**An Roinn Turasóireachta, Cultúir,
Ealaíon, Gaeltachta, Spóirt agus Meán**
Department of Tourism, Culture,
Arts, Gaeltacht, Sport and Media

Our Ref: **G Pre00220/2019**

02/02/2021

Re: Replacement of 7 manned level crossings at Limerick to Cork Line.

Figure 20: Aerial view of site XC219 Buttevant, showing geophysical survey results (greyscale image)

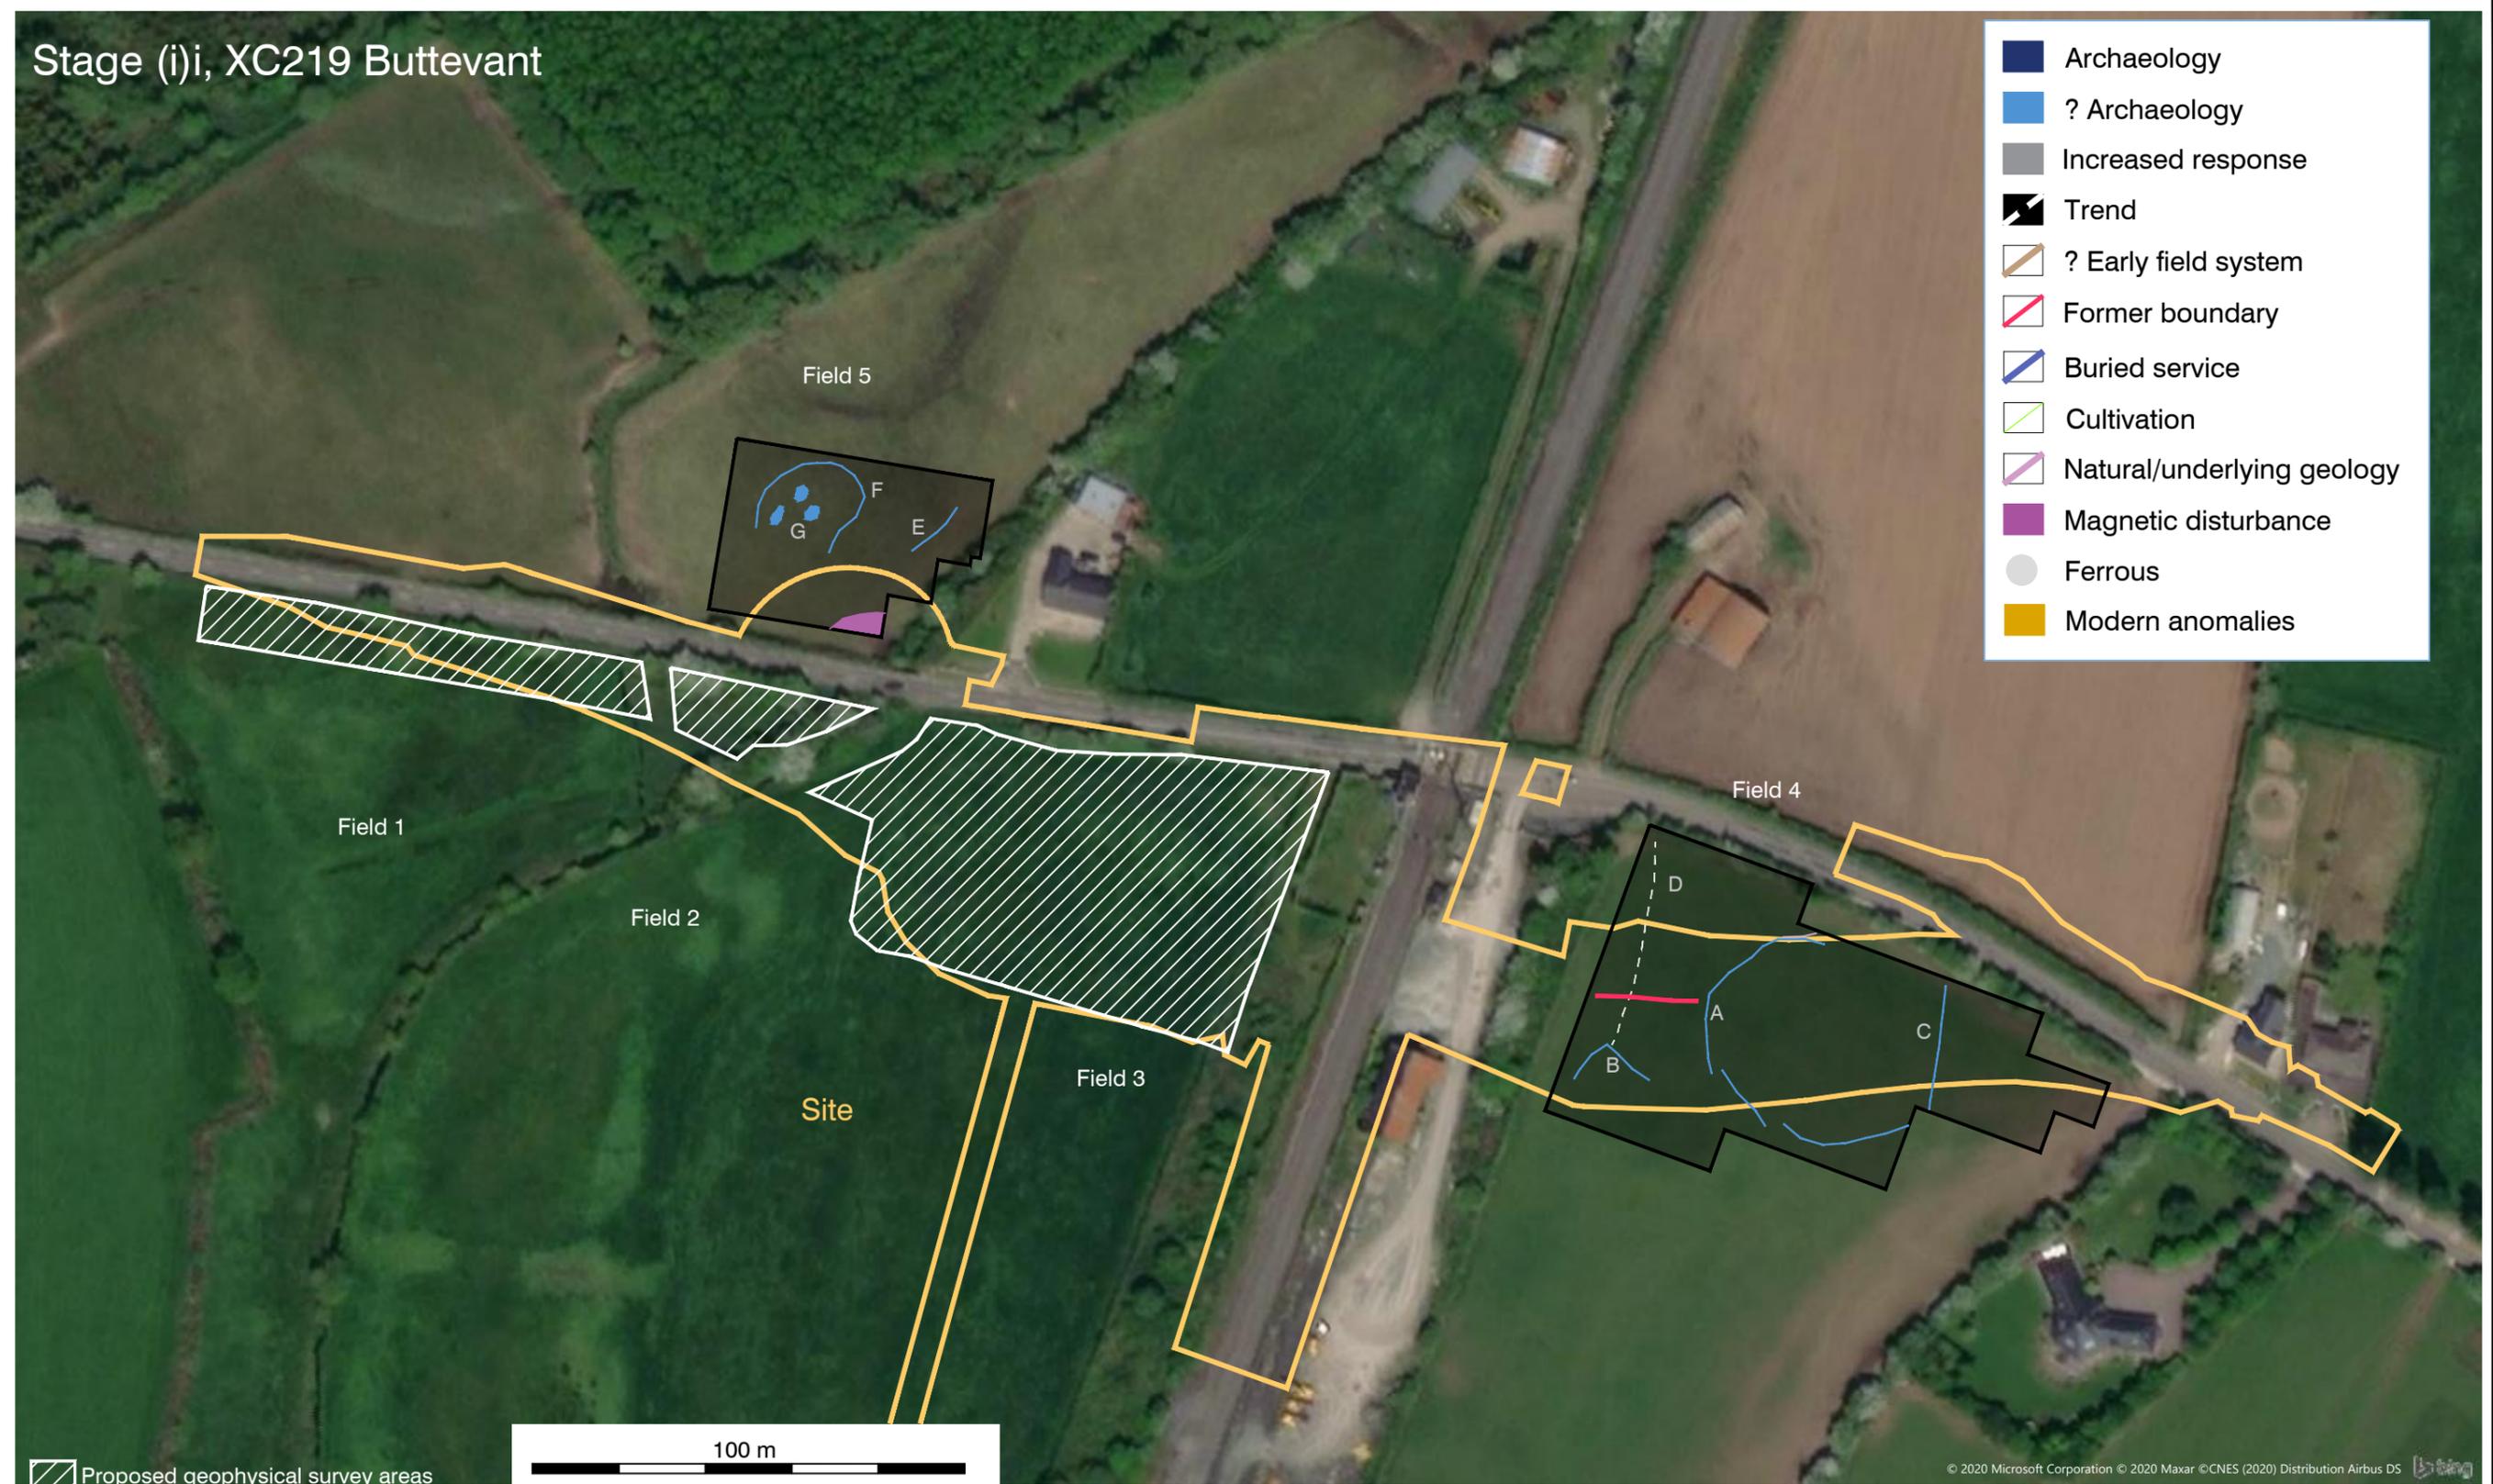
5. Archaeological Testing, based on the results of the Geophysical Survey (20R0239), shall take place within the route selected at Buttevant, Co. Cork. Testing shall be targeted around the area of the possible enclosure recorded by geophysics. Should significant archaeological features be recorded during testing, further mitigation will be required. This may include redesign to allow for preservation *in situ*, archaeological excavation and/or a combination of both strategies. The developer and archaeologist shall be advised by the NMS in these matters.
